# CITY OF ALBUQUERQUE

**RE:** Sunset Villa Subdivision Temporary Pond Recovery

**Grading Plan**

**Hydrology File: K12D003**

SUNSET VILLA GRADING AND DRAINAGE PLAN	DRAWN BY	WCWJ
		DATE	3-17-16
		21401-LAYOUT-1-06-13	
		SHEET #	6 OF 25
		JOB #	21401

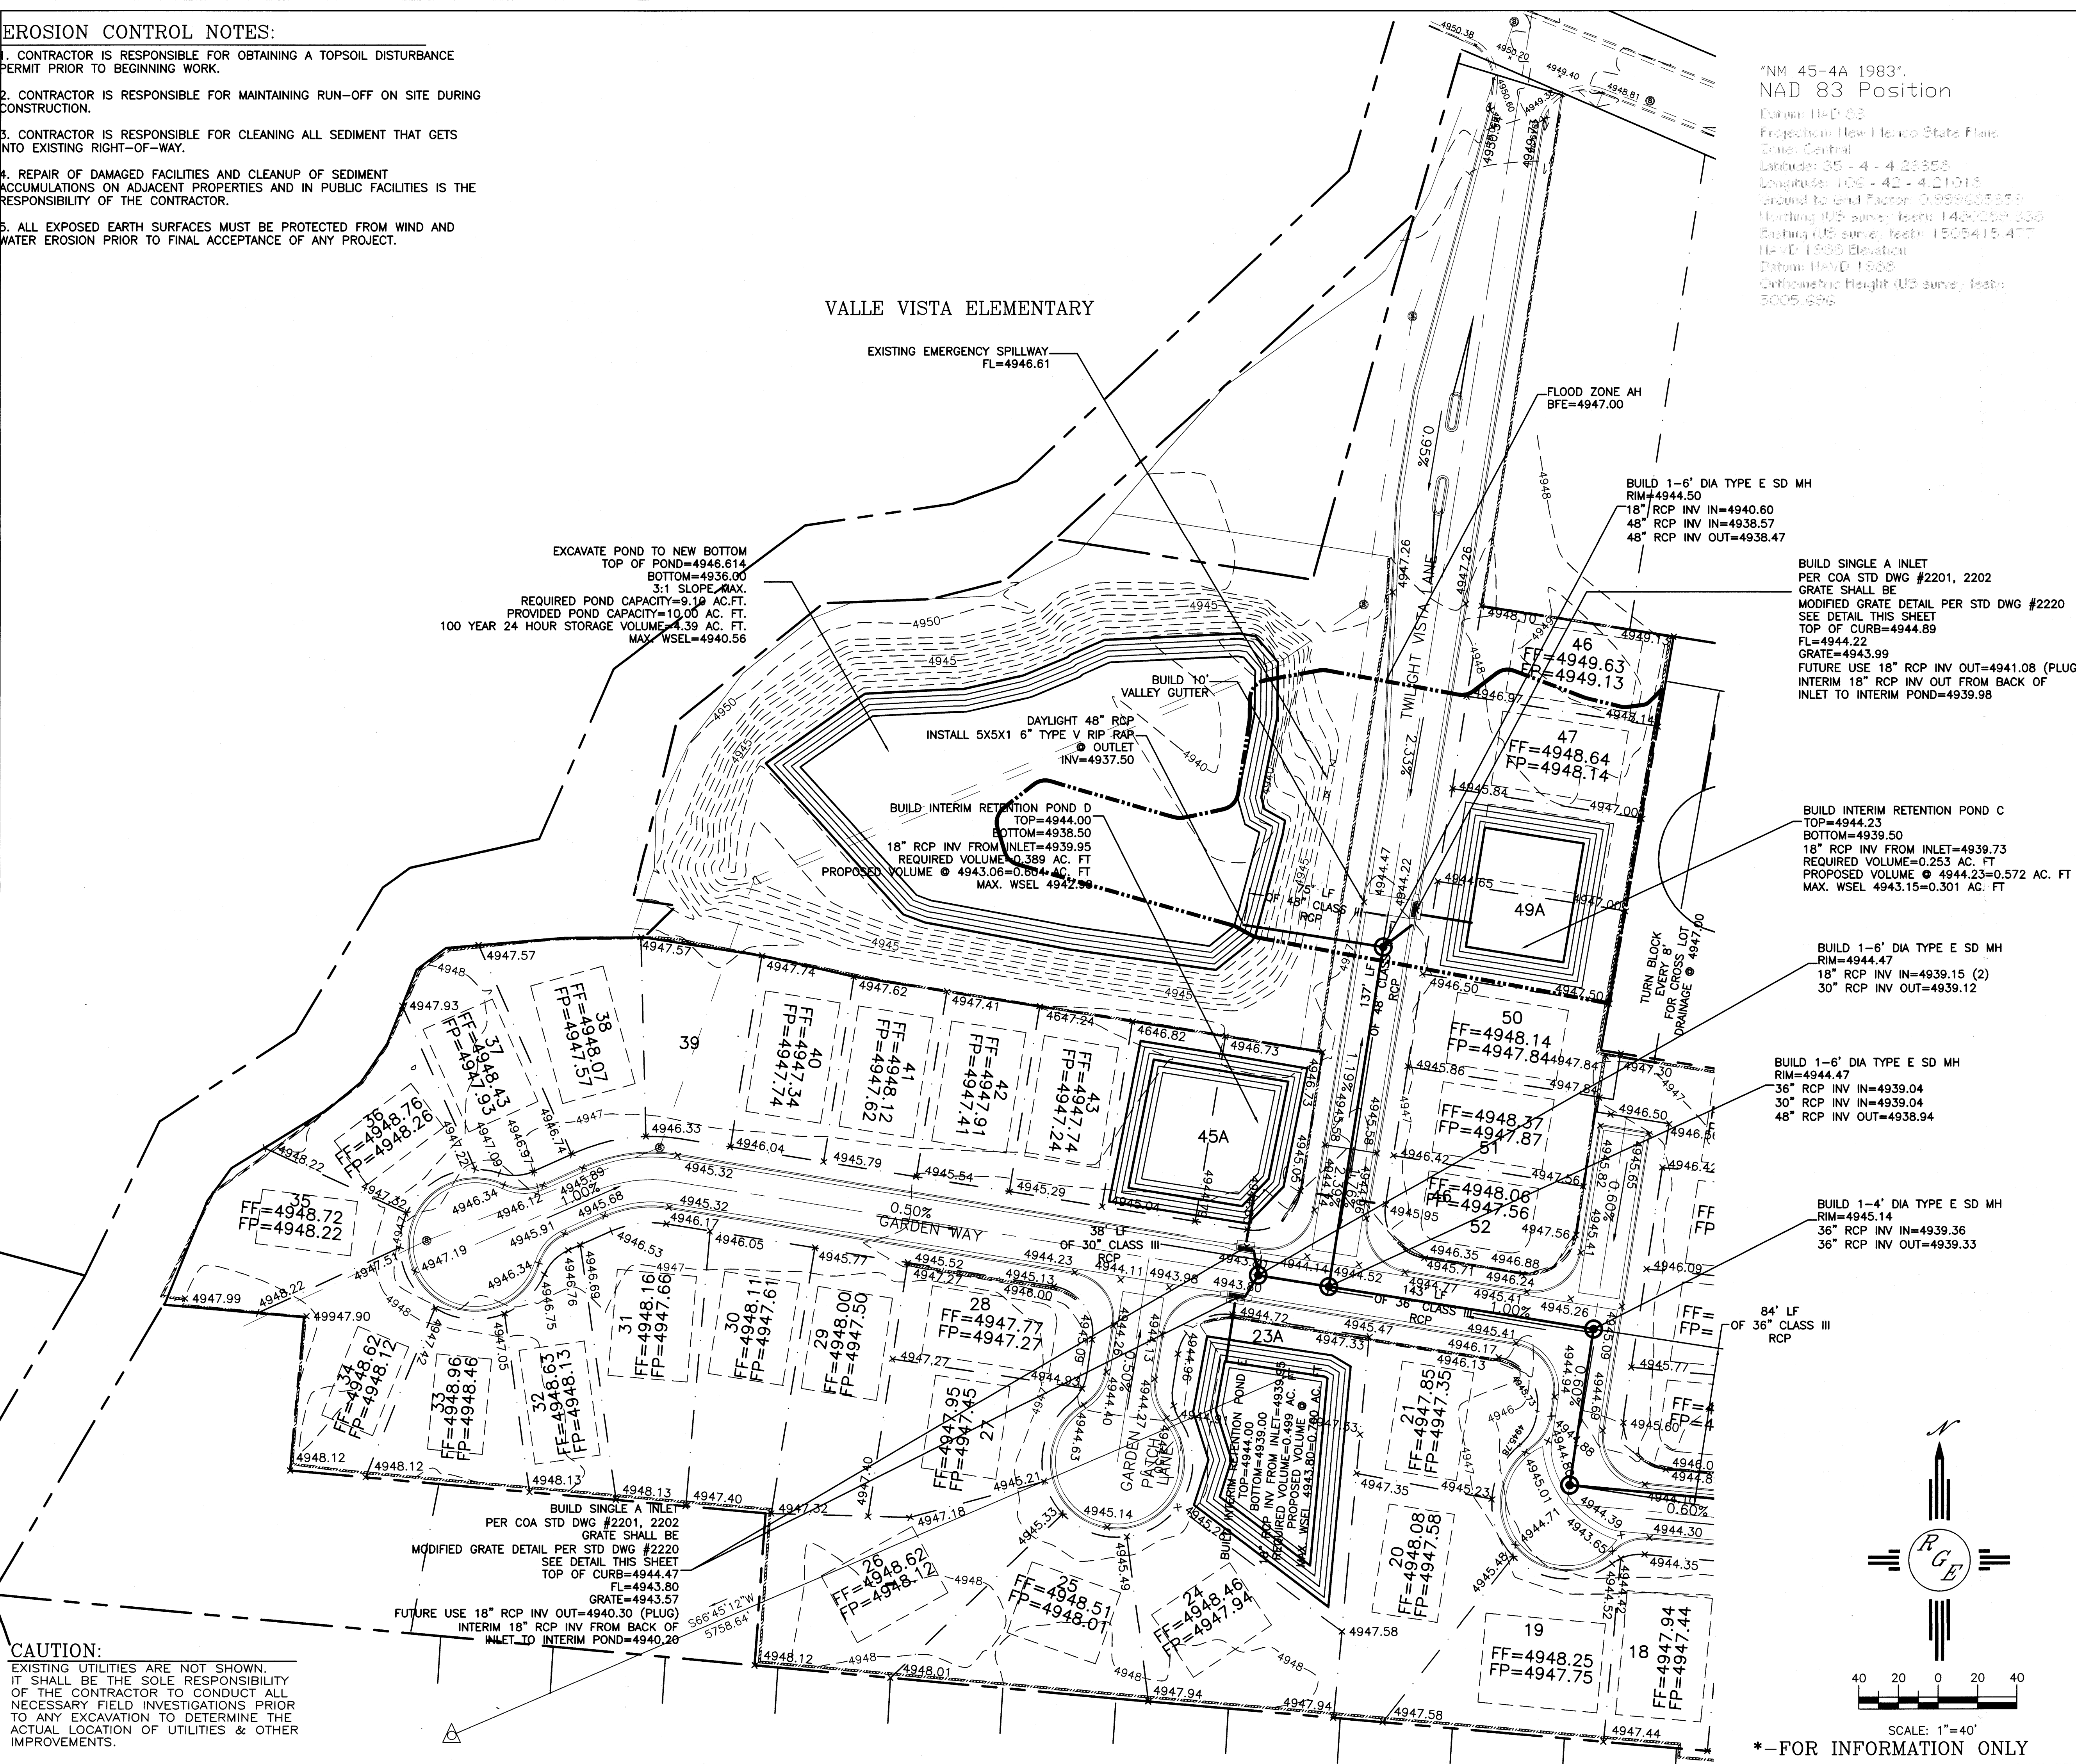
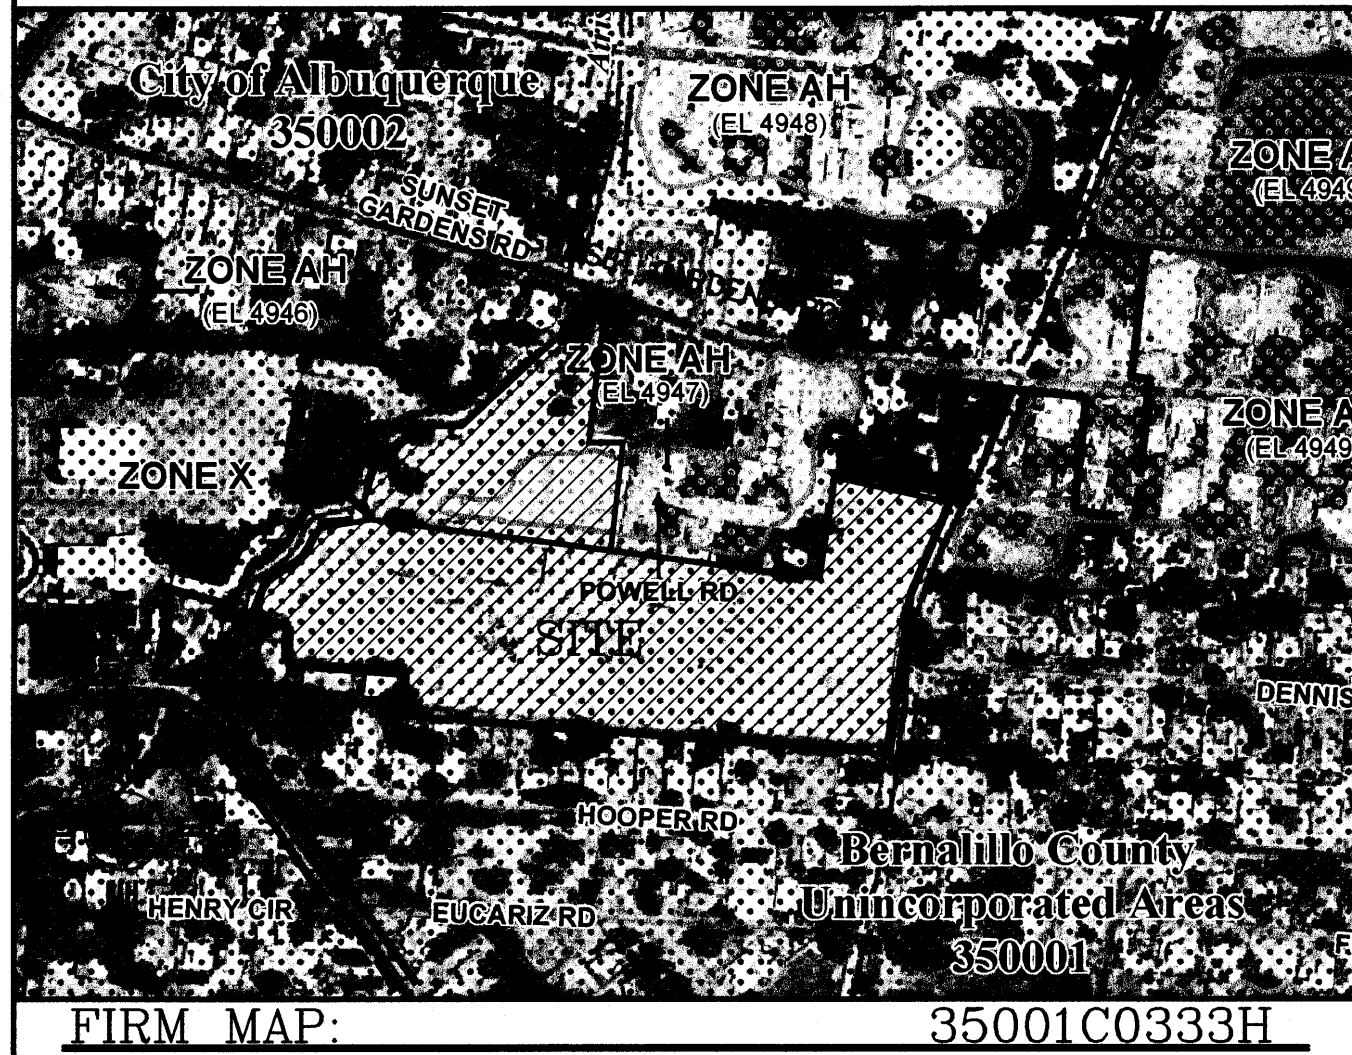
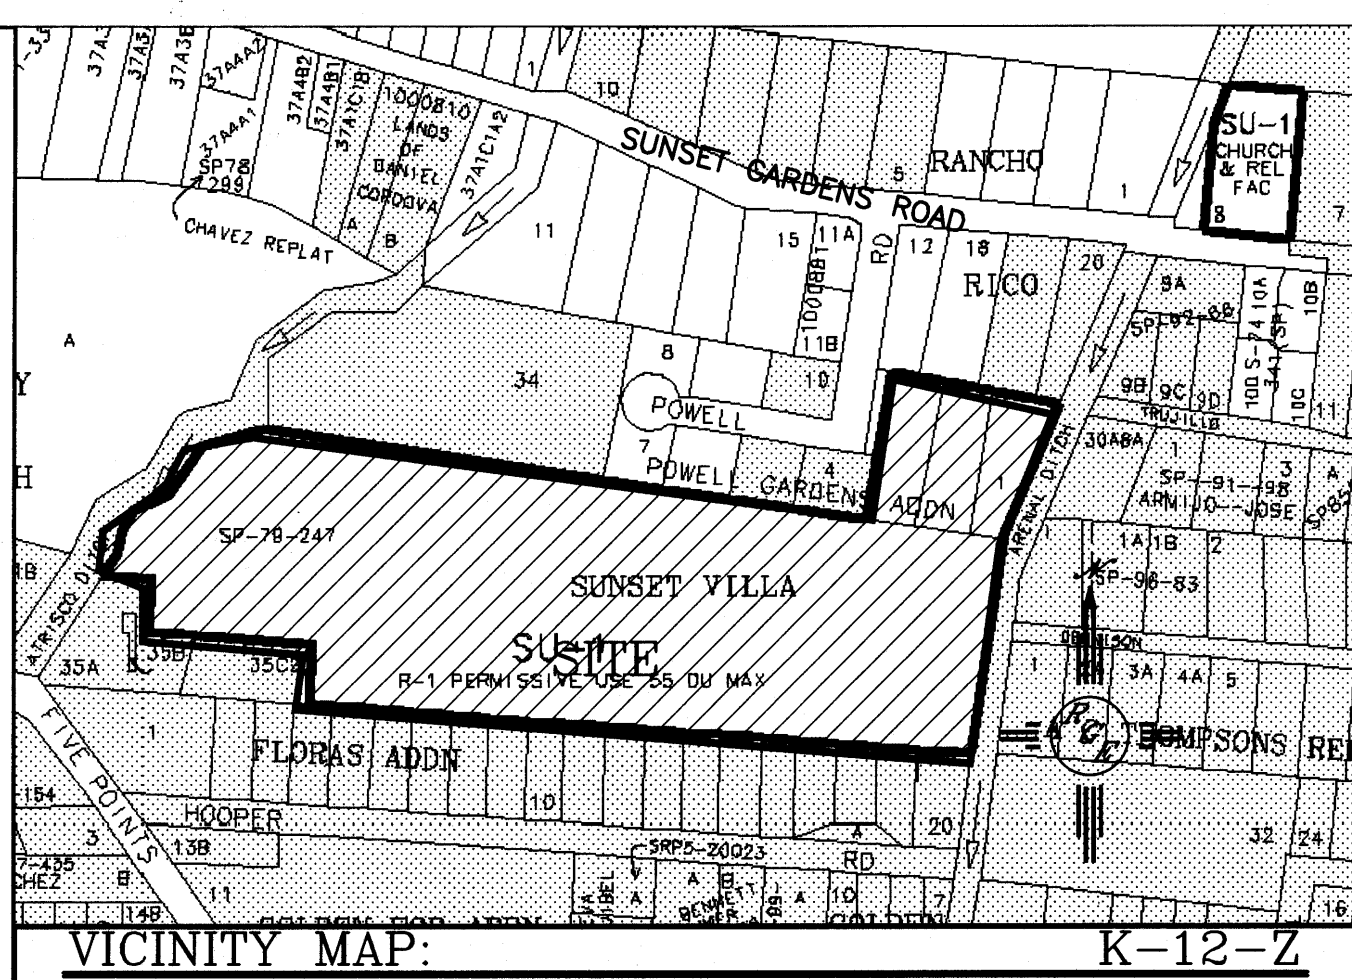
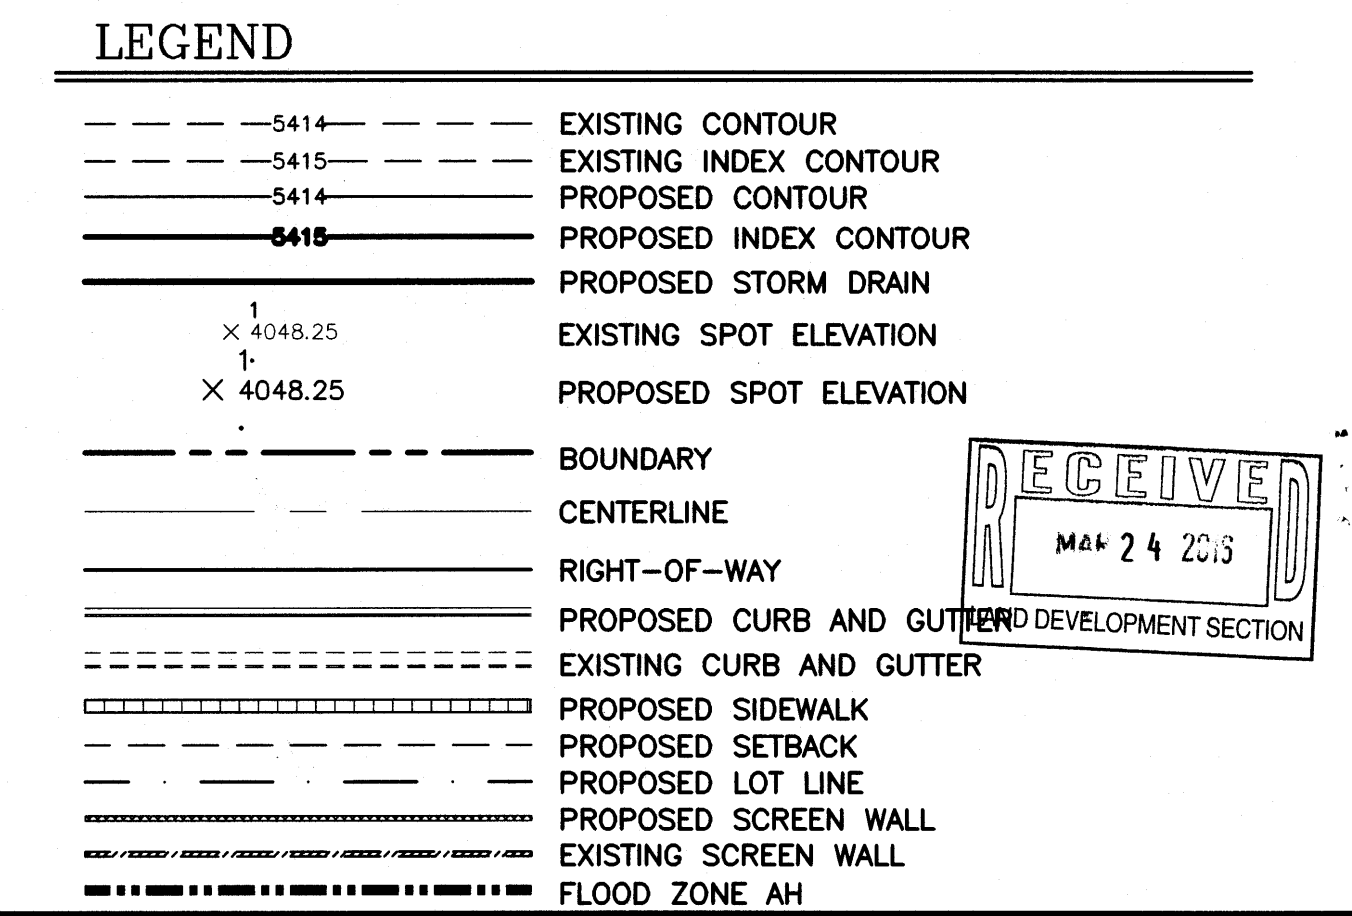
1. Show the work to remove the temporary RCP stubs into the temporary retention ponds and the work to activate the permanent pipe network into the County Pond.

- 4. Provide existing and proposed contours on the grading plan and show the limits of grading.
- 5. This project requires an ESC Plan, submitted to the Stormwater Quality Engineer (Curtis Cherne PE, ccherne@cabq.gov or 924-3420).
